Developer Services
Southern Water
Sparrowgrove House
Sparrowgrove
Otterbourne
Hampshire
SO21 2SW

Your Ref
EG/81/18/HH
Our Ref
PLAN-026262
Date
31/01/2019

Proposal: Proposed conservatory to the rear and side elevation.
Site: 73 Barnham Road, Eastergate, PO22 0EP.
EG/81/18/HH

PROPOSED FLOOR PLAN

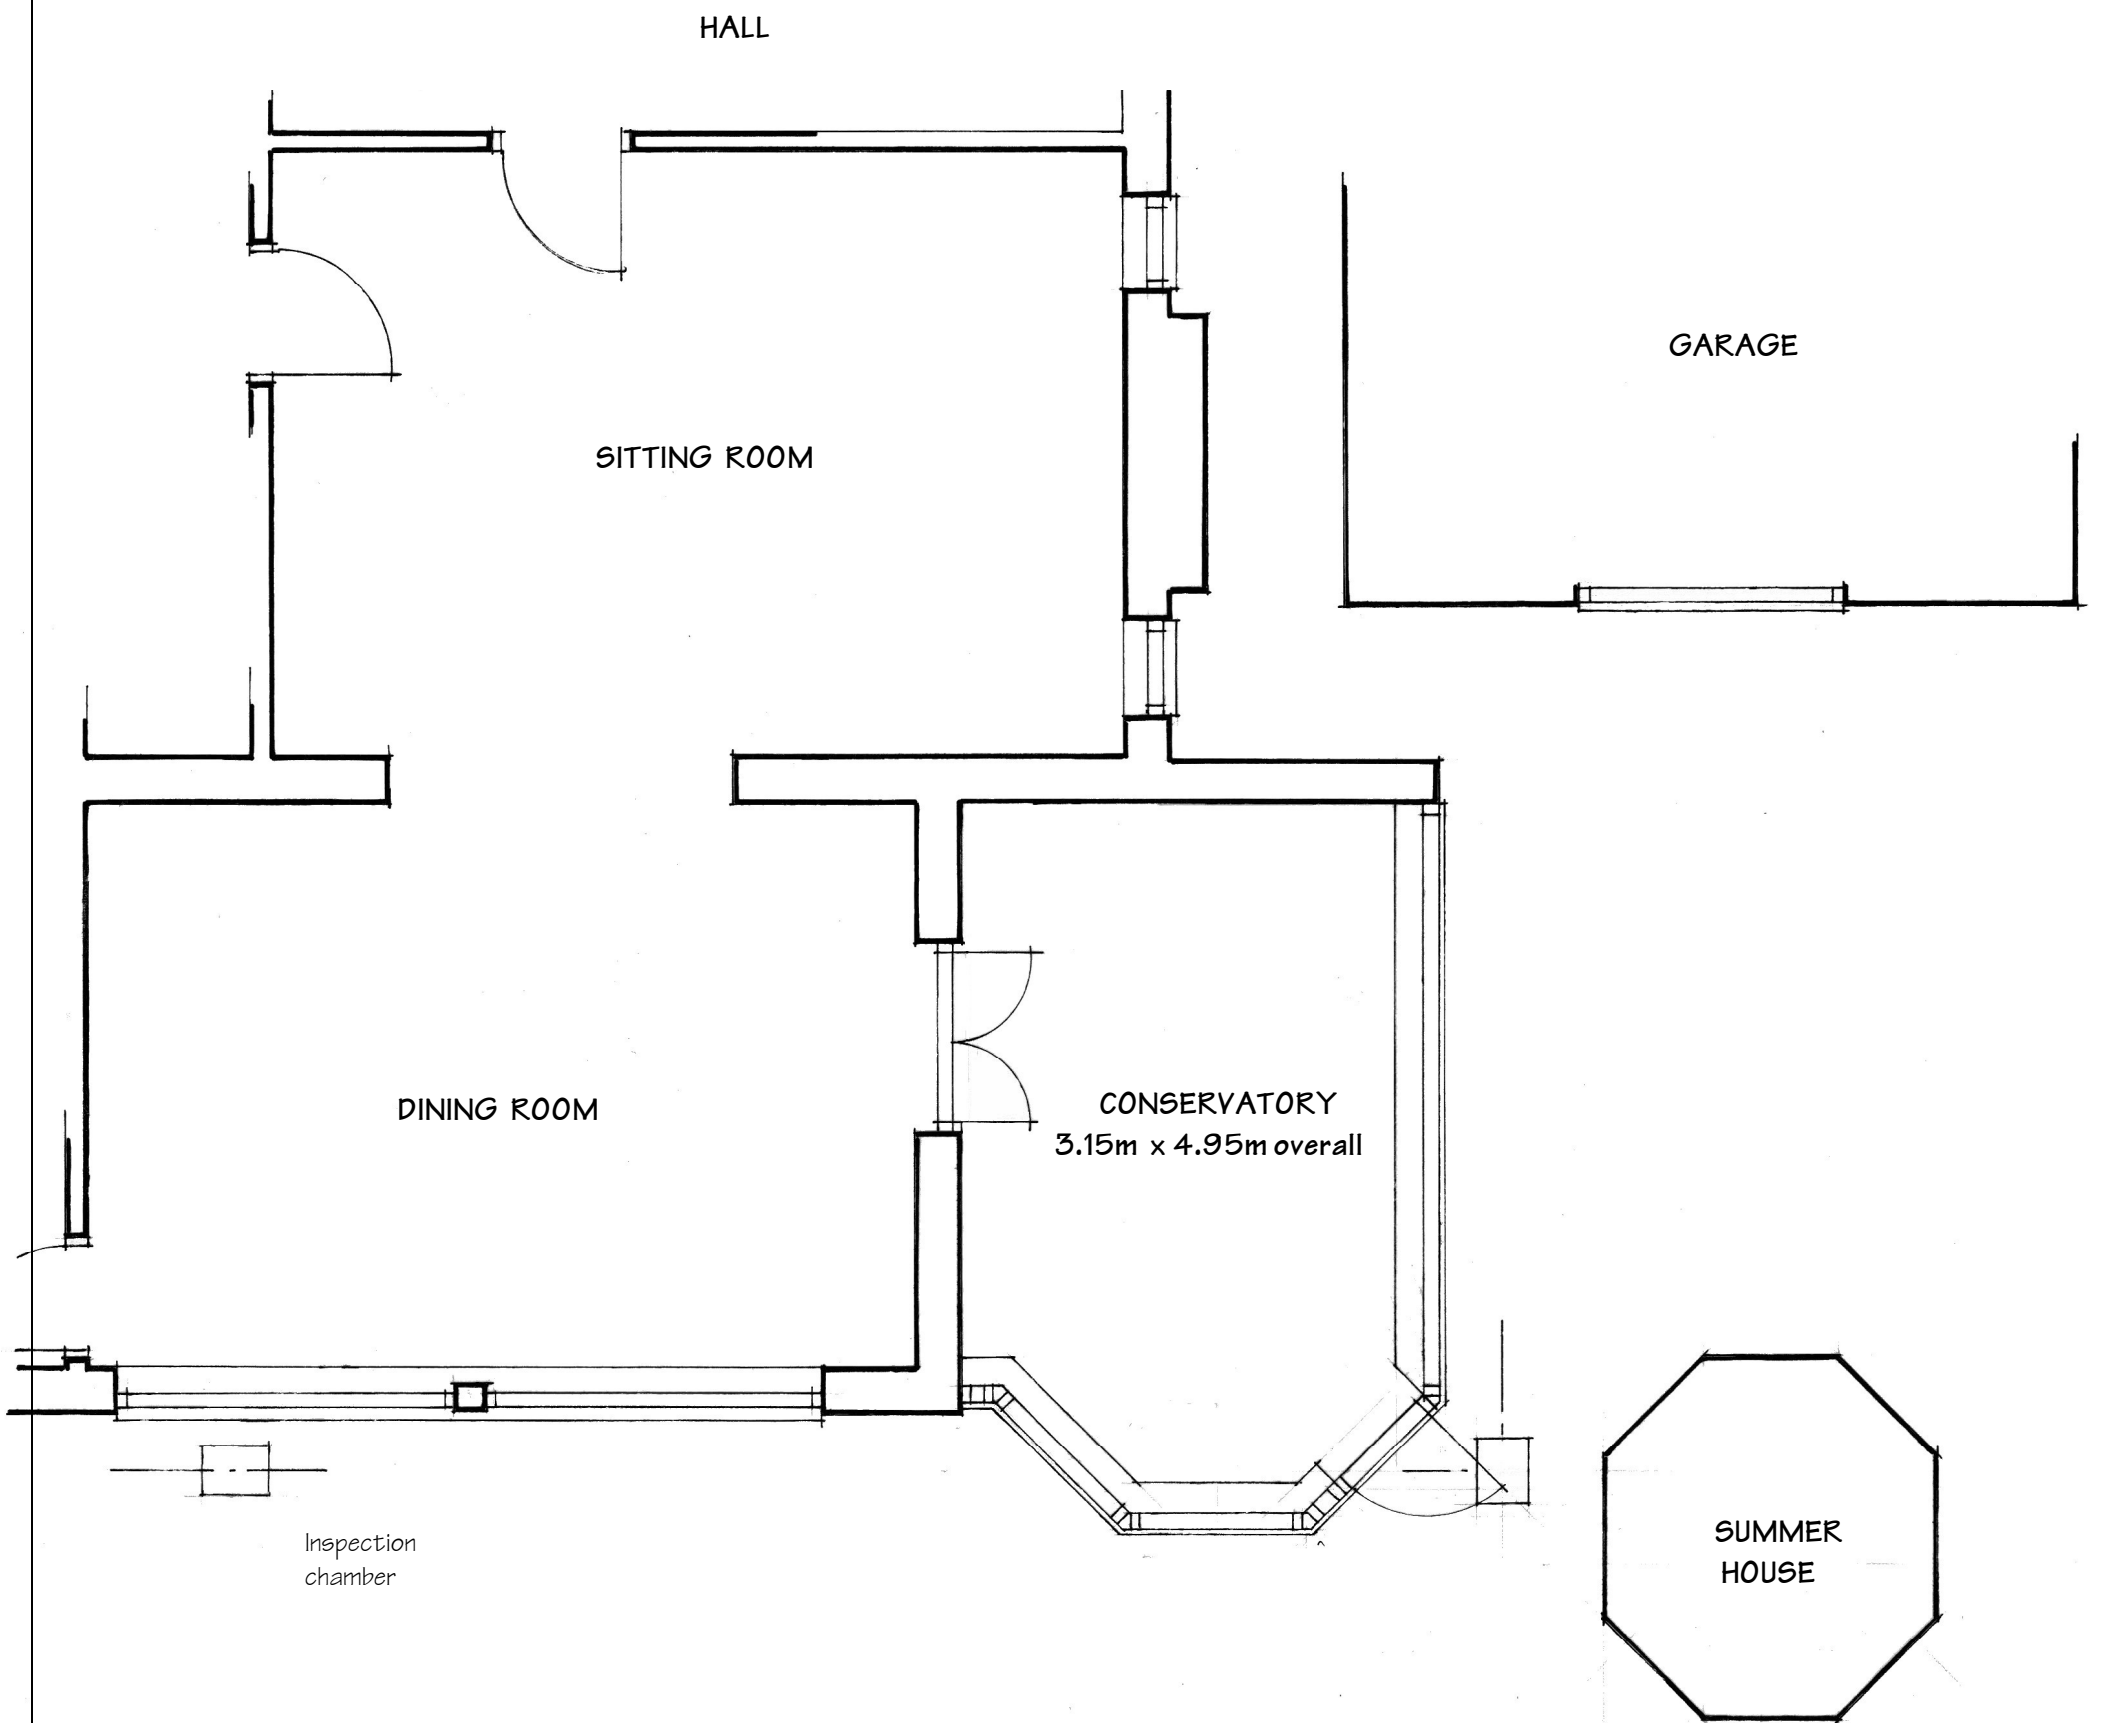
Submitted plan shows that the proposed extension lies over/ close to a sewer (not shown on our records). It appears that the developer is intending to build close to a public sewer. Building over a "public sewer" is not normally permitted by Southern Water. An investigation of the sewer is required to ascertain its condition, the number of properties served, and potential means of access, before any decision can be made as to whether it would be acceptable for the proposed development close to the sewer. Part H of the Building Regulations dictates that the matter is determined by the sewerage undertaker – in this case Southern Water.

The applicant is advised to discuss the matter further with Southern Water, Sparrowgrove House, Sparrowgrove, Otterbourne, Hampshire SO21 2SW, [REDACTED] or www.southernwater.co.uk.
